Figure 1
LOCALITY PLAN AND
MINERAL AUTHORITIES

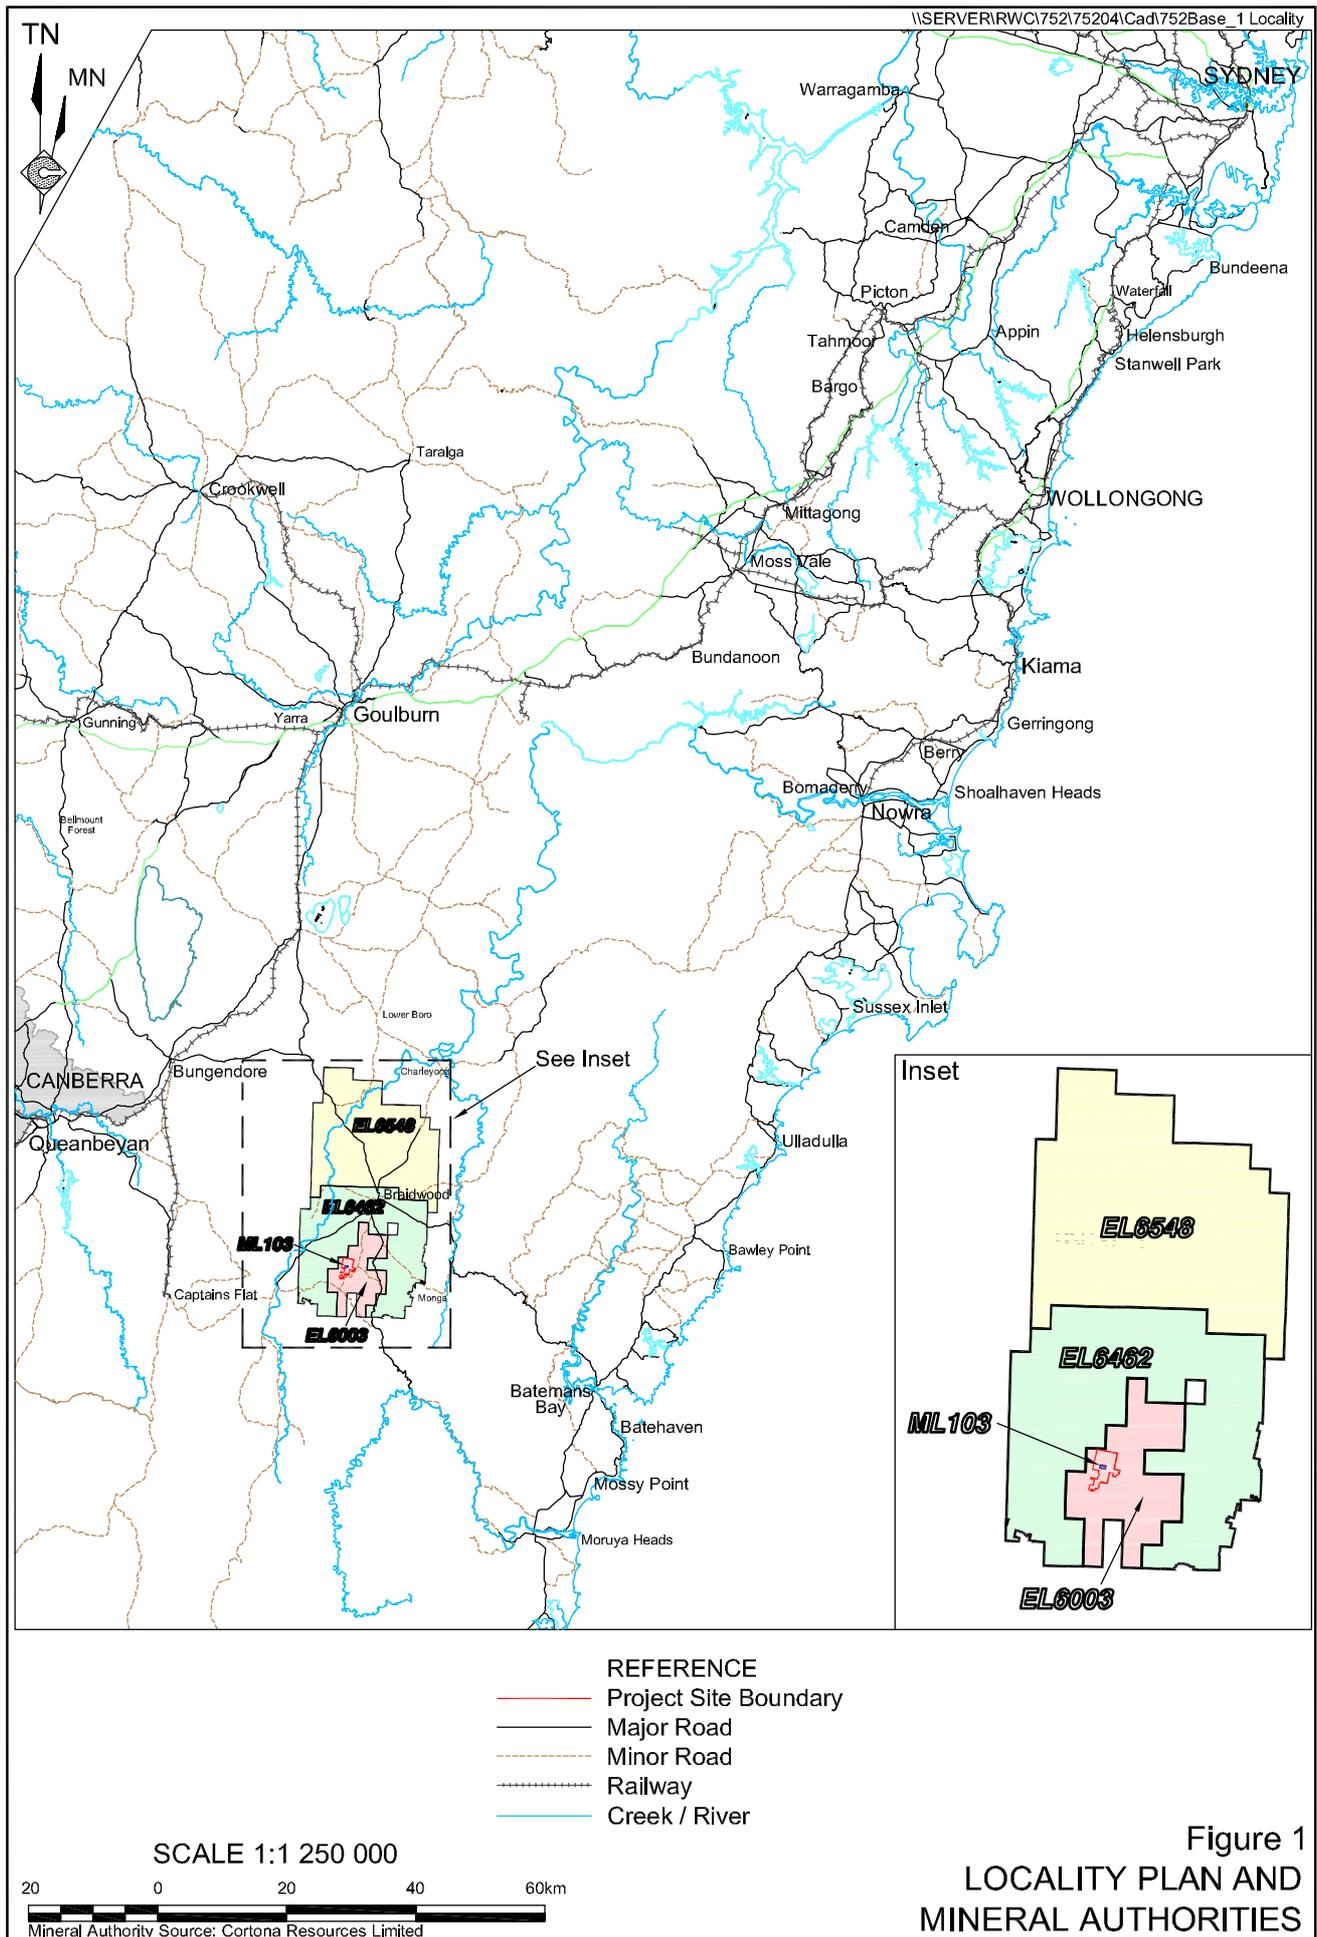
A submission was received from Brian and Karis Sanderson (Submission 045). In that submission it was noted that while their residence (Residence R33) was included in the *Environmental Assessment*, specific reference to their property was not. **Figure 1** has been amended to include reference to the property, namely Lot 1 DP 1093136, as Property 115.
